Subject: RE: Planning Consultation on Y/21/20/DOC

APPLICATION NO: Y/21/20/DOC

Site Address: Land rear of 2,4,& 6 Gladstone Road Yapton BN18 0JP

Application for approval of details reserved by condition following the grant of Y/22/17/PL relating to conditions 3-schedule of materials & finishes & 8- surface water drainage details.

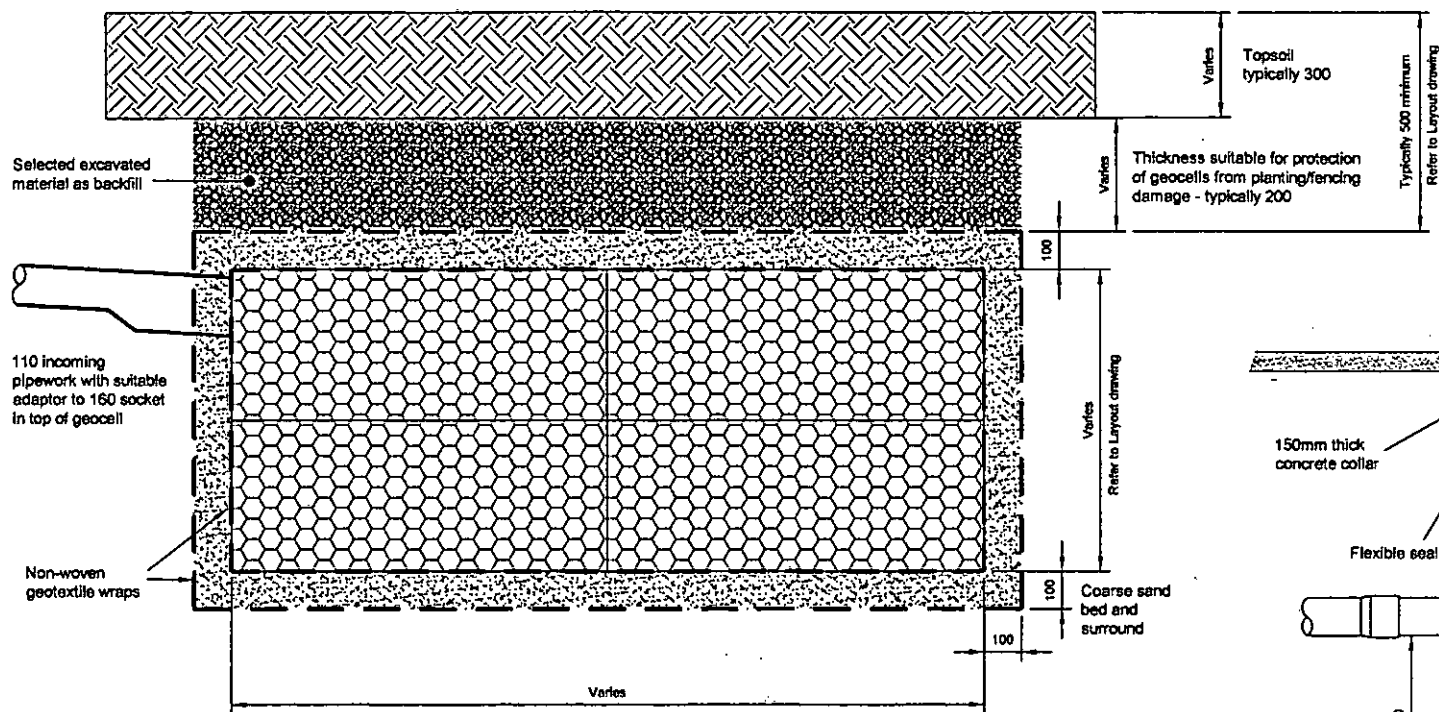
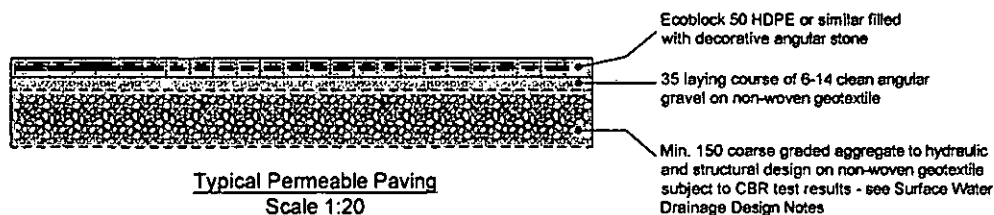
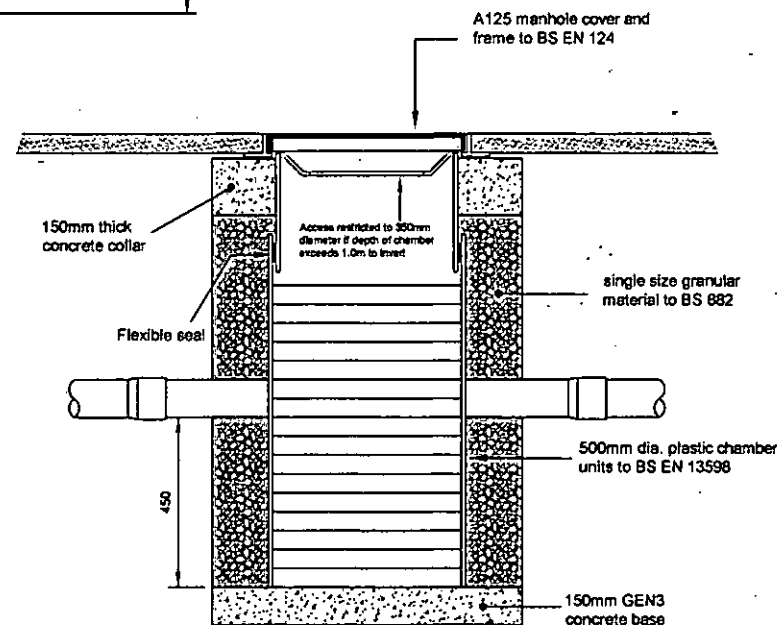
- 4: Done: Please upload the construction detail with the updated plans.

1. There is no winter infiltration testing. Infiltration testing was completed in June 2018. Infiltration testing should be completed in the winter period and the results used to inform the design.
2. The application references a 'groundwater monitoring point in an adjacent field', as recording groundwater at 1.74mbgl in place of winter groundwater monitoring. It *may* be possible to use this data, but more detail needs to be supplied. What is the location of the field? Where is the monitoring data to be found? When was the period of monitoring?
3. The impermeable area on the calculations does not agree with the impermeable area shown on the plan (110m² on the calcs, 165m² on the plan).
4. Need a construction detail for the pipe bed and surround.

Scale	As shown	A1 original	A3
Drawing Number	1795/SK1	Revision	-

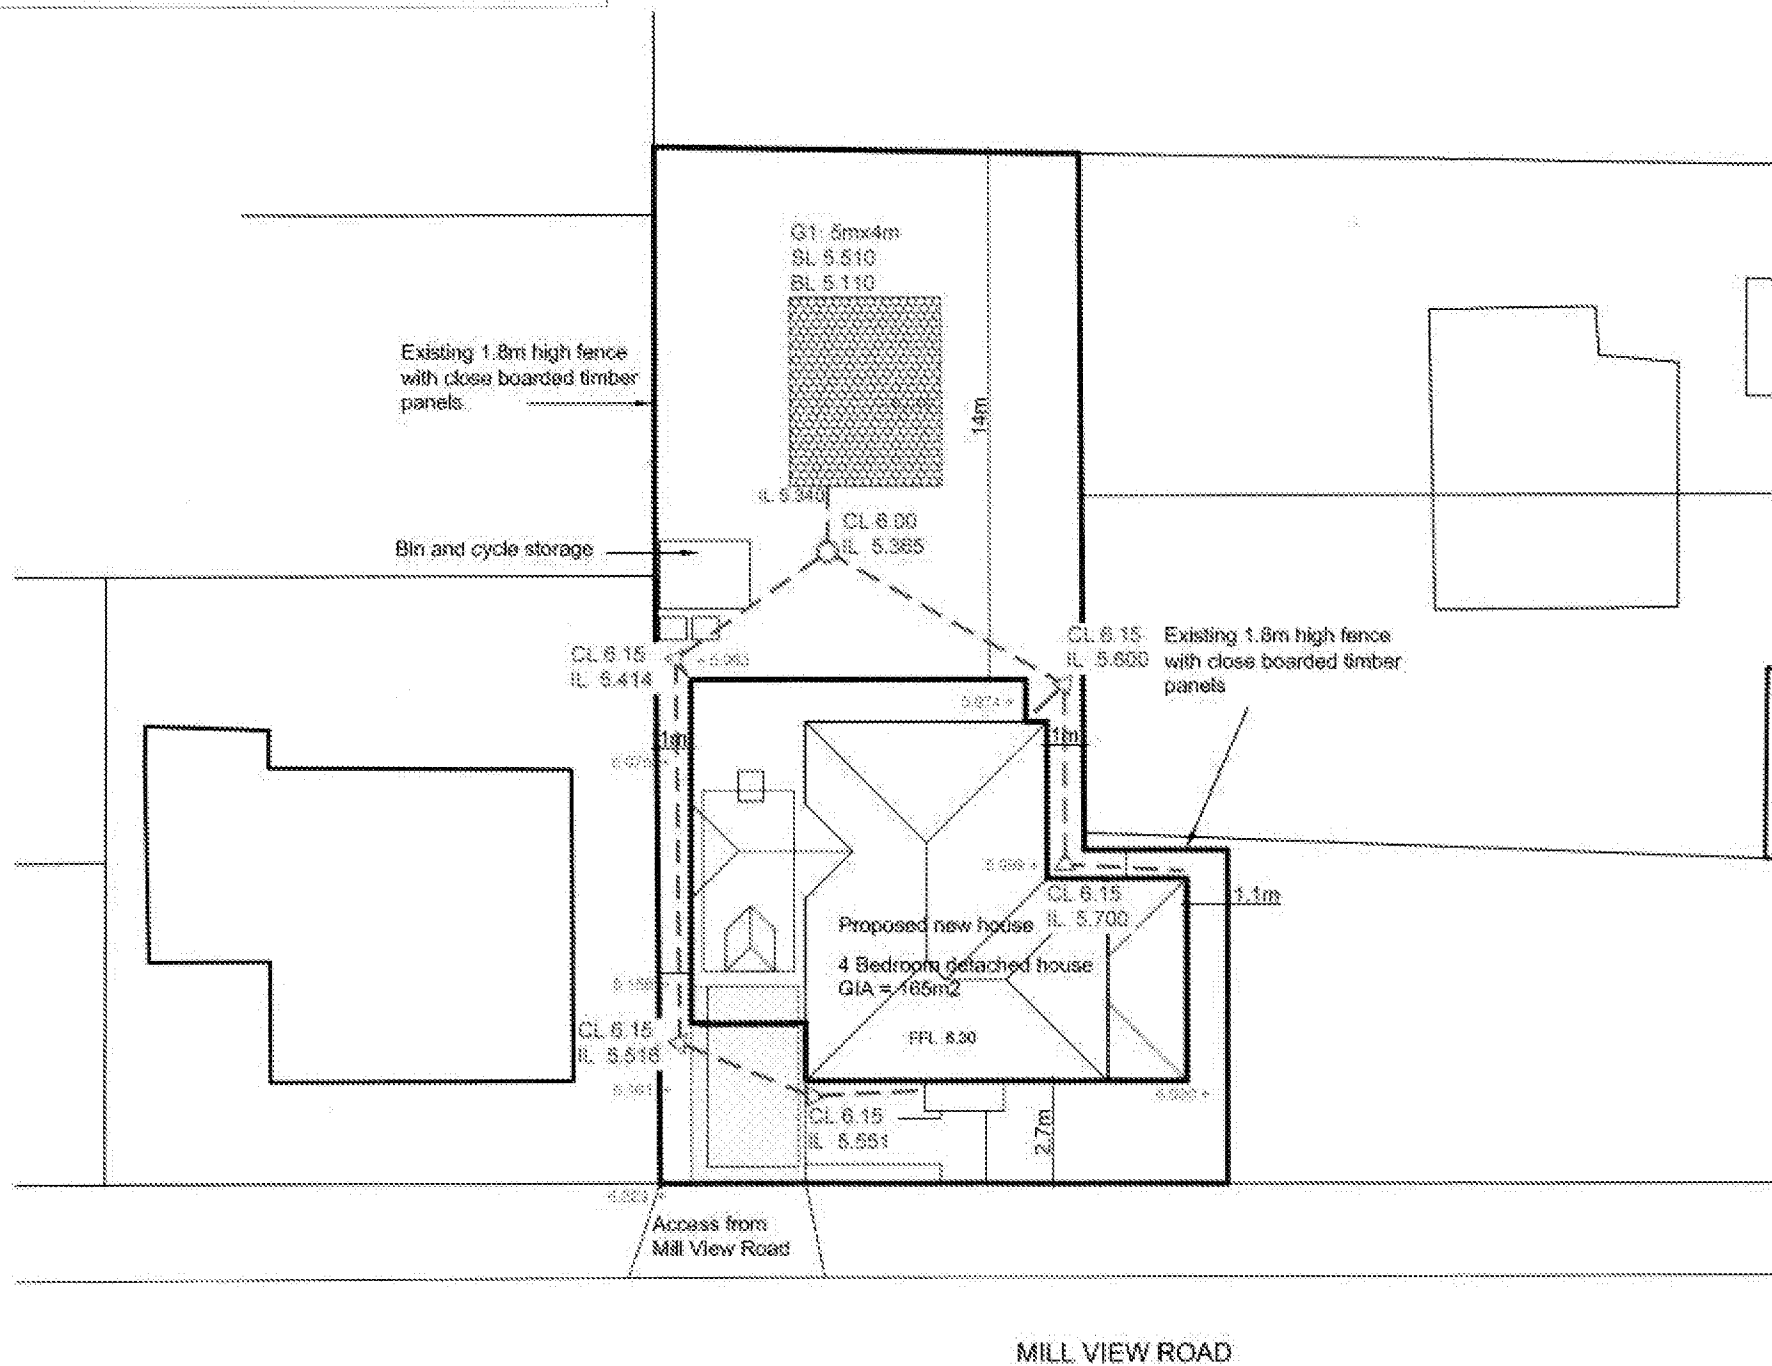
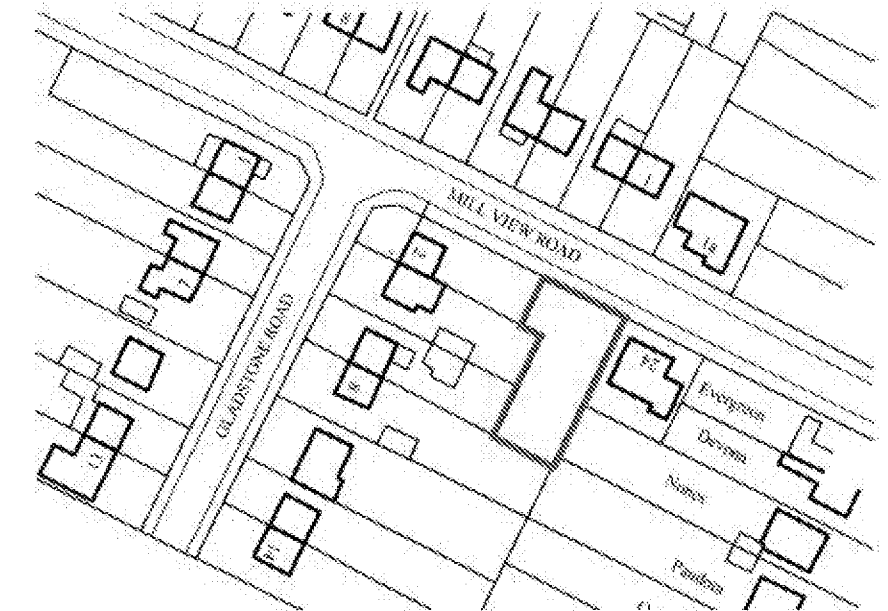
- 1: The infiltration has been completed in June 2018, not the winter. The applicant's engineer has claimed that this was agreed with Laura Gibbons on the basis of comparable infiltration rate recorded at a neighbouring property. The applicant must supply the application number and document reference to locate this data easily (for both myself and future public viewers). If the data is comparable then we will accept the results.

- 2: The applicants engineers have proposed including the location of the dipped borehole on the plans. This is good, but I also want them to include a link for the location of the monitoring data (again both for myself and public viewers). I personally have no issue with the use of boreholes within a reasonable distance but the data must be easily accessed to ensure transparency.

- 3: The engineers have claimed that the plan is misleading as the impermeable roof area is 115m², please ensure this is clear on the plan and update the calculations accordingly.
